Ribble Valley Borough Council  
Housing & Development Control

Your ref 3/2022/0537  
Our ref D3.2022.0537  
Date 13<sup>th</sup> July 2022

Application no: **3/2022/0537**

Address: **Land Adjacent to Ferns Northcote Road Langho BB6 8BG**

Drawing No.
2203-PL-01

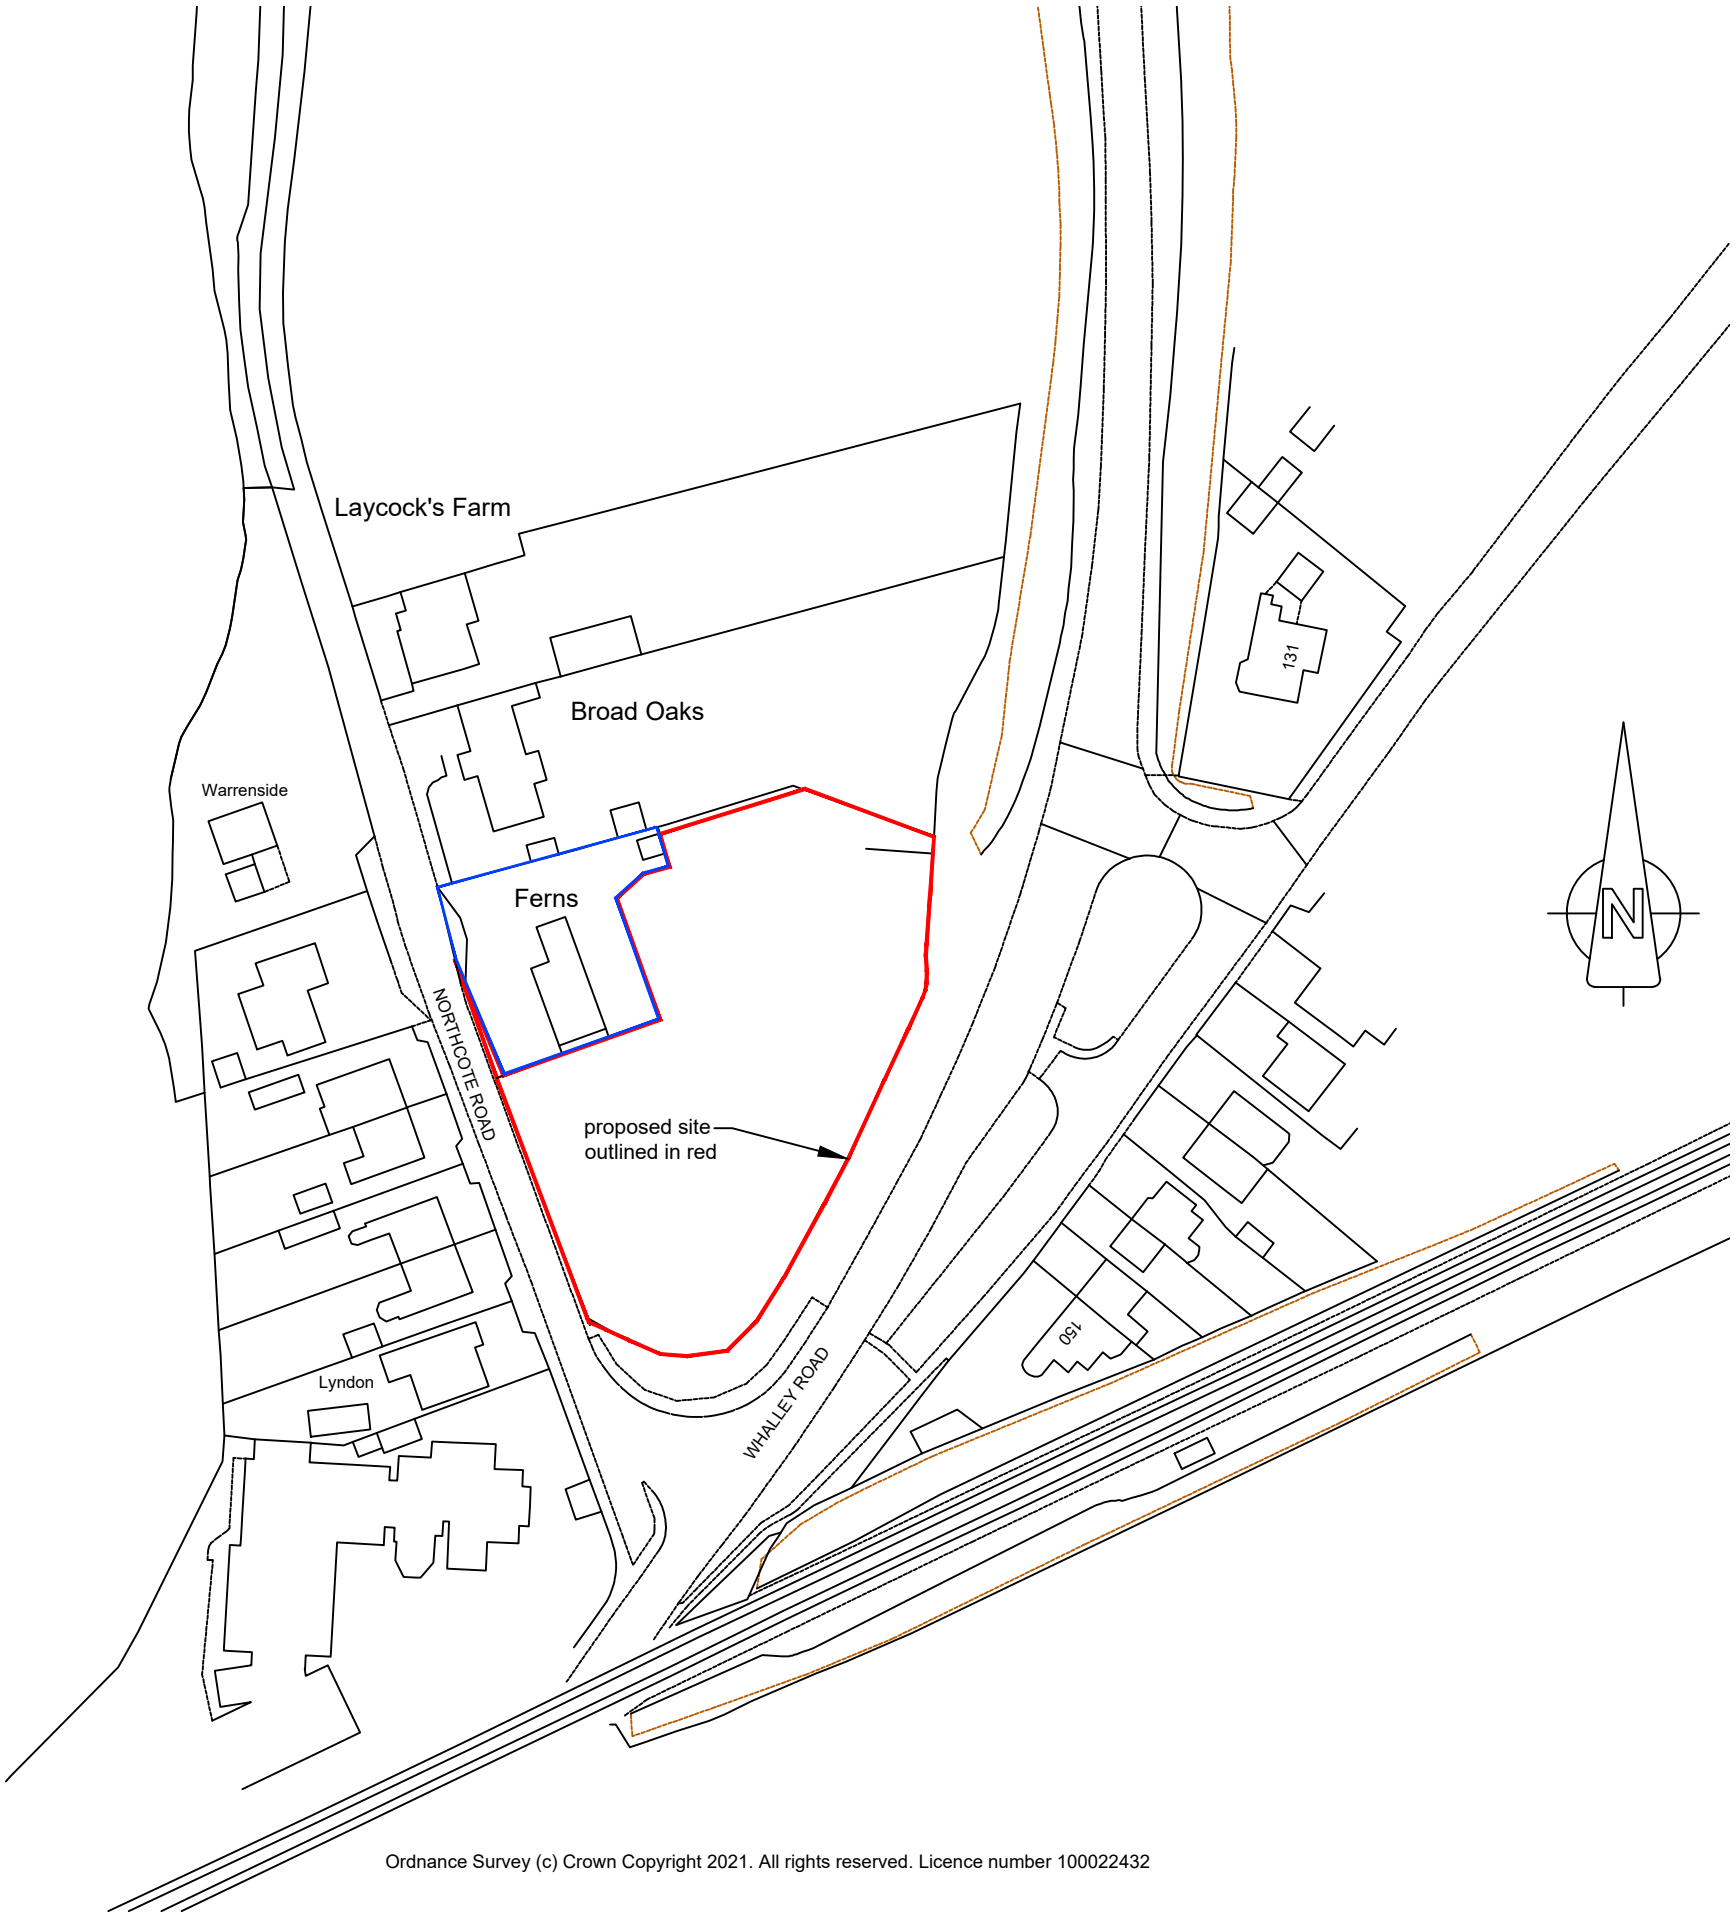
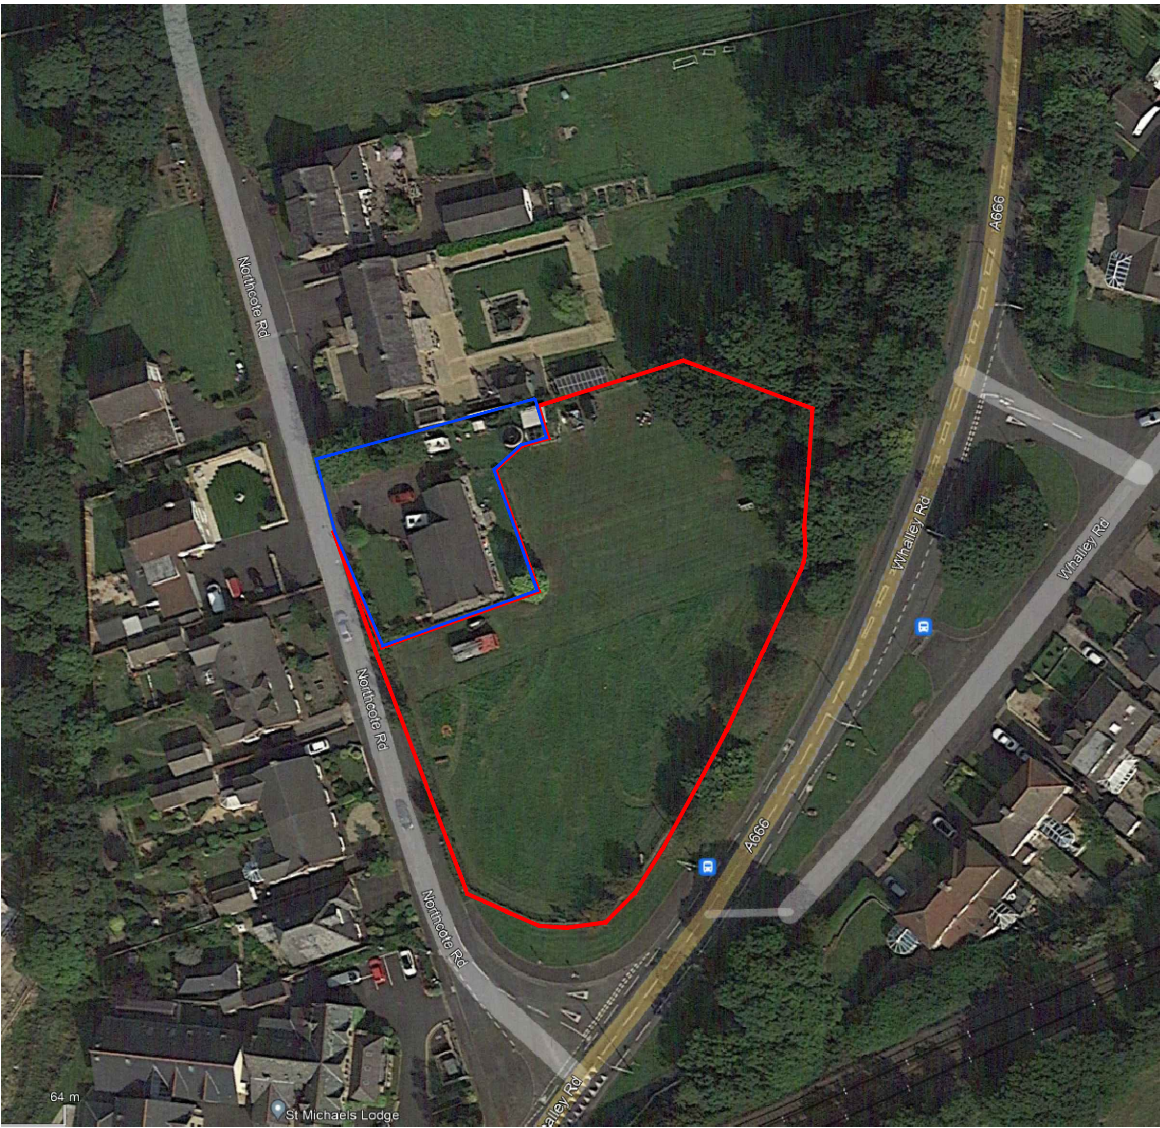
The LHA have also reviewed the drawing and are aware that vehicular visibility splays of 2.4m x 60m are provided in both directions. While the LHA are able to accept the splay to the left of the access, the LHA require the splay to the right to be redrawn. This is because the splay overlooks third party land which the LHA are unable to accept. This is because the Applicant is unable to prevent any obstructions which would hamper visibility to be implemented.
